May 4, 2016

SUBJECT: **Request for Modification of the Section 404 Individual Permit, Section 401 Water Quality Certification, Isolated Waters State General Permit, and Neuse River Riparian Buffer Certification** for the proposed East End Connector from NC 147 (Durham Freeway/Buck Dean Expressway) to north of NC 98 (Holloway Street) in Durham, Durham County, North Carolina, Division 5. Federal Aid Project No. NHF-76-1(2), TIP No. U-0071.

The purpose of this letter is to request a modification to the United States Army Corps of Engineers (USACE) Section 404 Individual Permit and North Carolina Division of Water Resources (NCDWR) Section 401 Water Quality Certification, Isolated Waters State General Permit, and Neuse River Riparian Buffer Certification for the above-referenced project.

In addition to this cover letter, please find enclosed revised Wetland Permit Drawing Sheet Nos. 30, 53, 55, 60, 90, and 91 of 91; revised Buffer Permit Drawing Sheet Nos. 6, 16, and 18 of 18; new ABF Freight Wetland Permit Drawing Sheet Nos. 1 and 2 of 2 for new Site No. 33, which is associated with the loss of property remediation between the N.C. Department of Transportation (NCDOT) and ABF Freig

ABF Freight
Permit Drawing
Sheet 1 of 2
Added April 2016

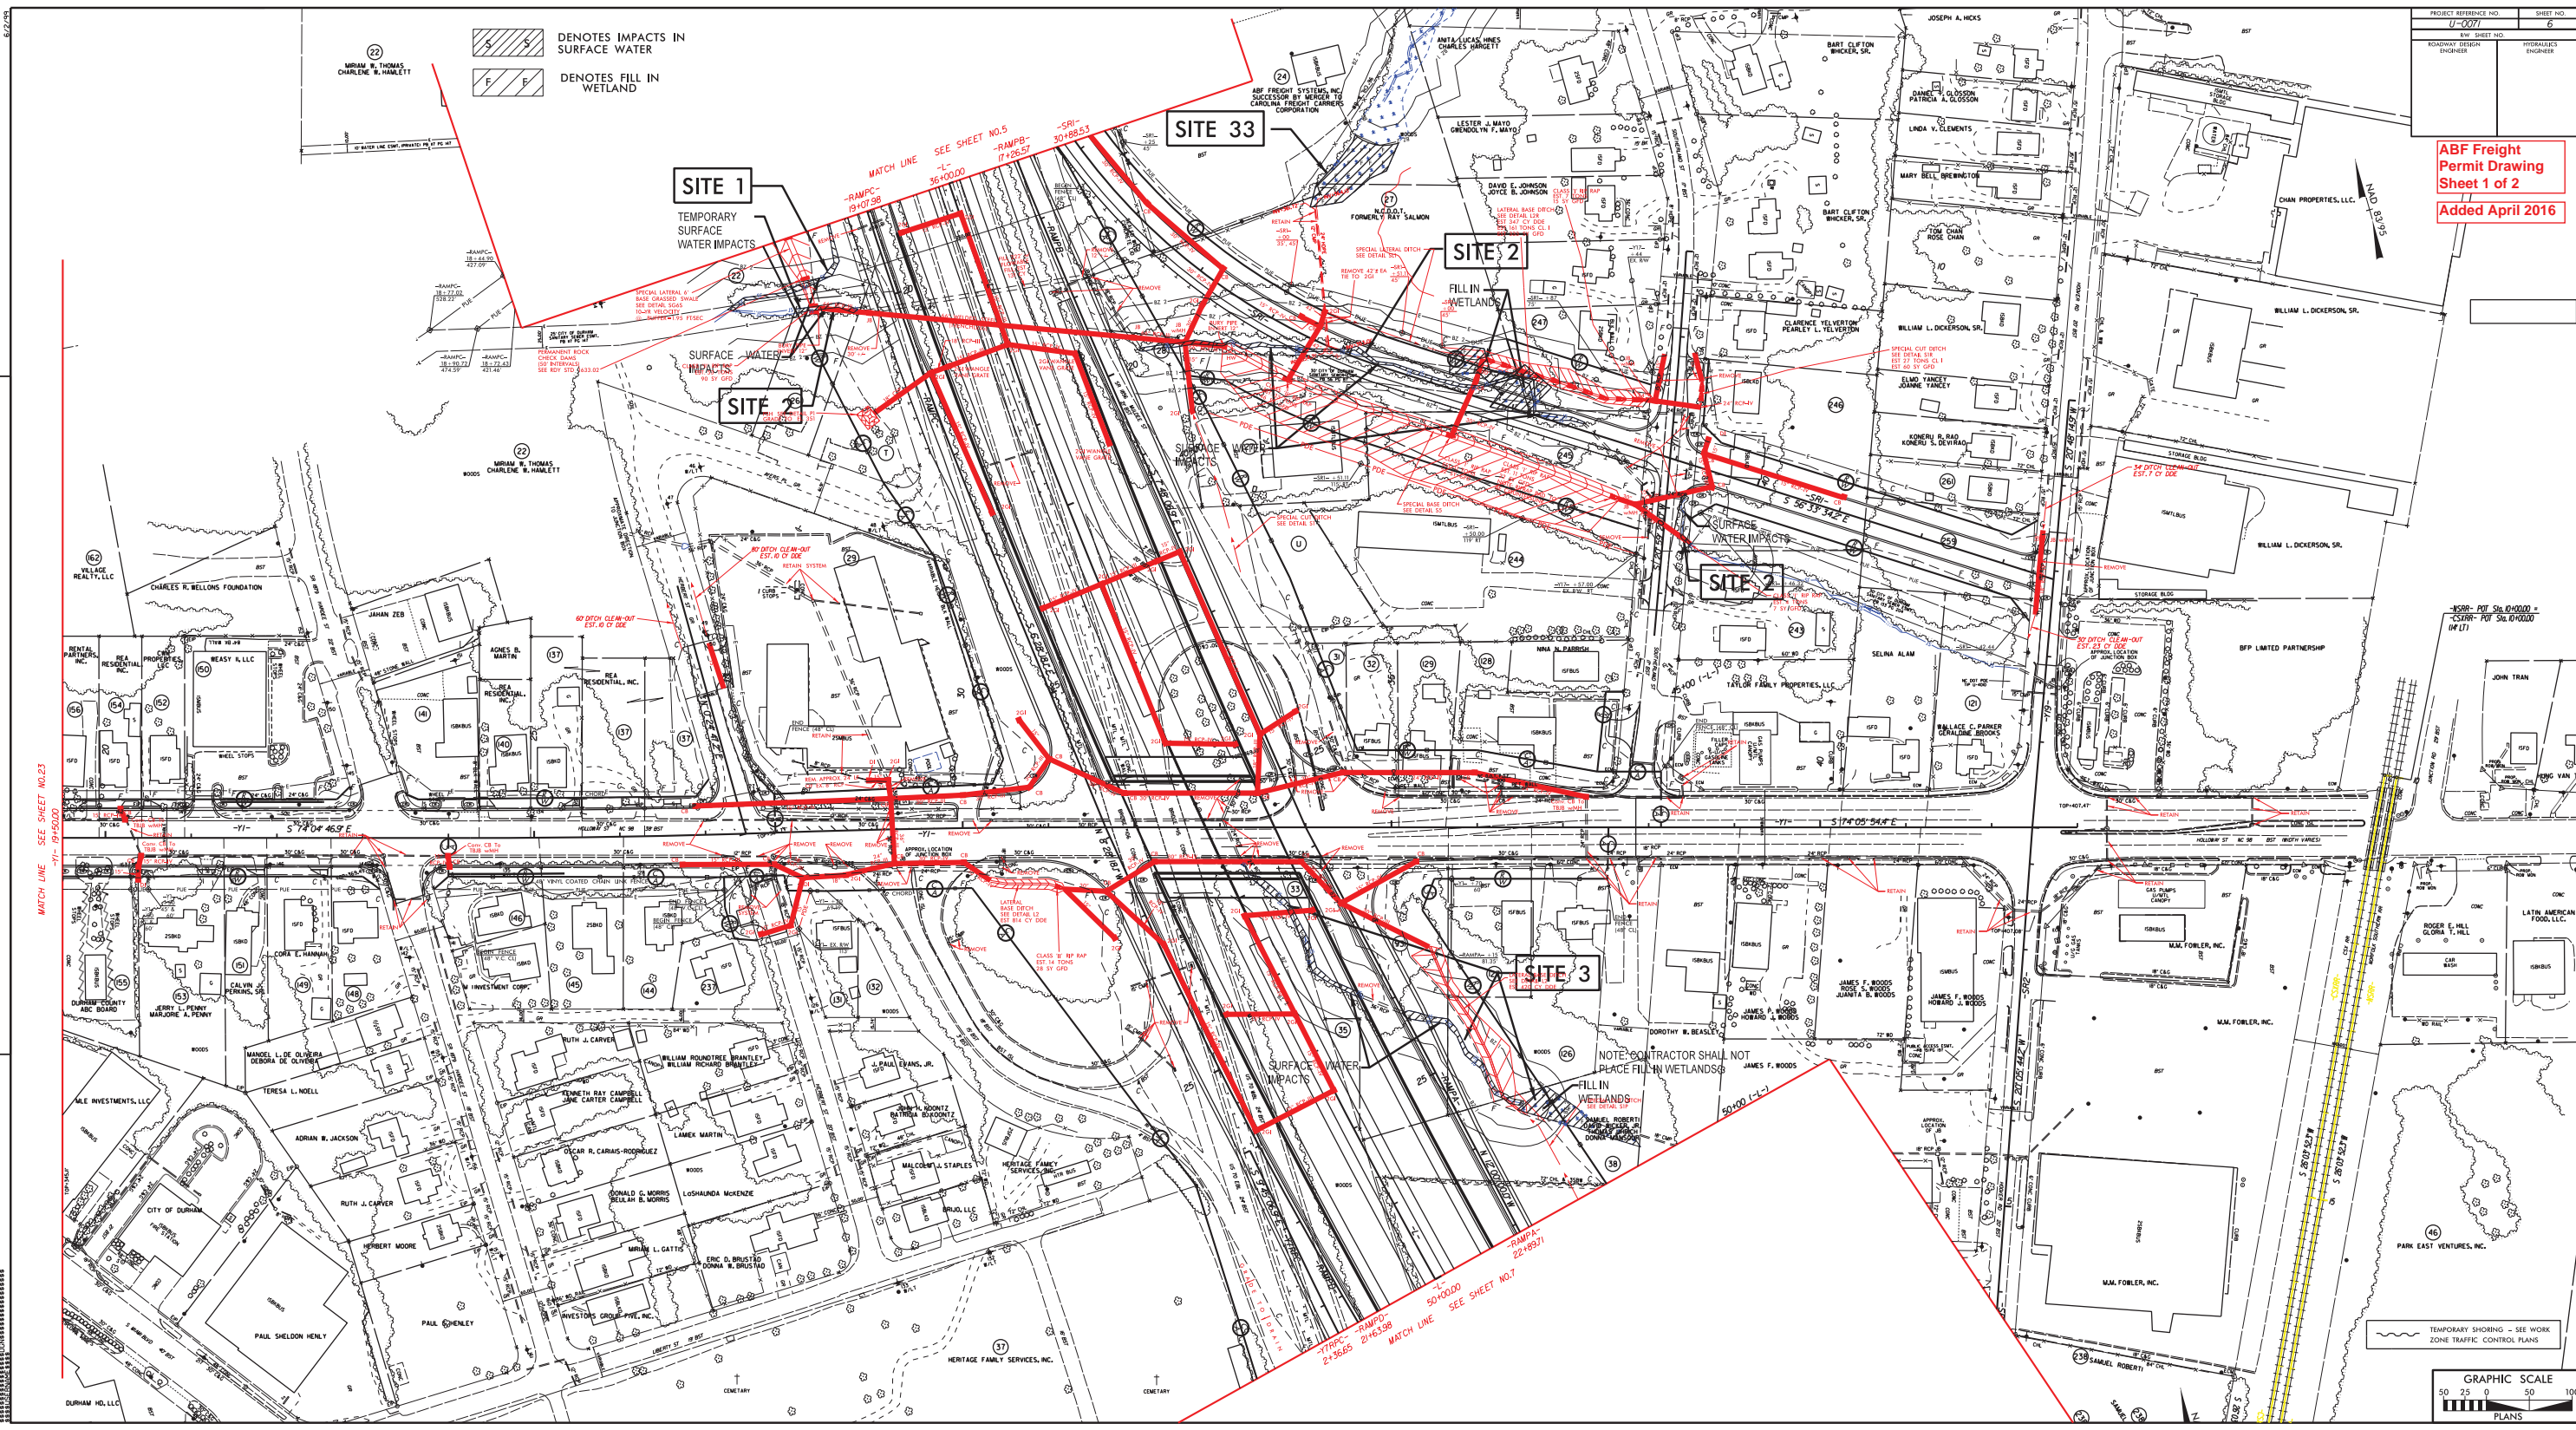
Permit Site 33

- ABF Freight Corporation, Horvath Associates (representing ABF Freight), and NCDOT have been working on a plan to remediate the loss of property resulting from TIP Project No. U-0071 on the ABF Freight parcel located at 208 Muldee Street in Durham, North Carolina. The remediation plan consists of replacing the lost truck terminal parking spaces and necessary truck turning movement area (which were lost due to NCDOT ROW encroachment) on an adjacent property. This property will remain outside of the limits of the NCDOT ROW upon completion of U-0071. Within the proposed limits of disturbance for the proposed work, there is a small portion of a jurisdictional

wetland (Wetland WA) that needs to be impacted in order for the replacement parking areas to reasonably function for the intended uses. Additionally, for proper truck movements to occur and for the replacement area to be used as needed by the ABF Freight Corporation, the disturbance of this wetland area is unavoidable. A large portion of this wetland will remain undisturbed and this request is only for disturbance of the area necessary for the site to function properly.

- This design addition will result in 0.09 ac. of permanent fill at Site No. 33.
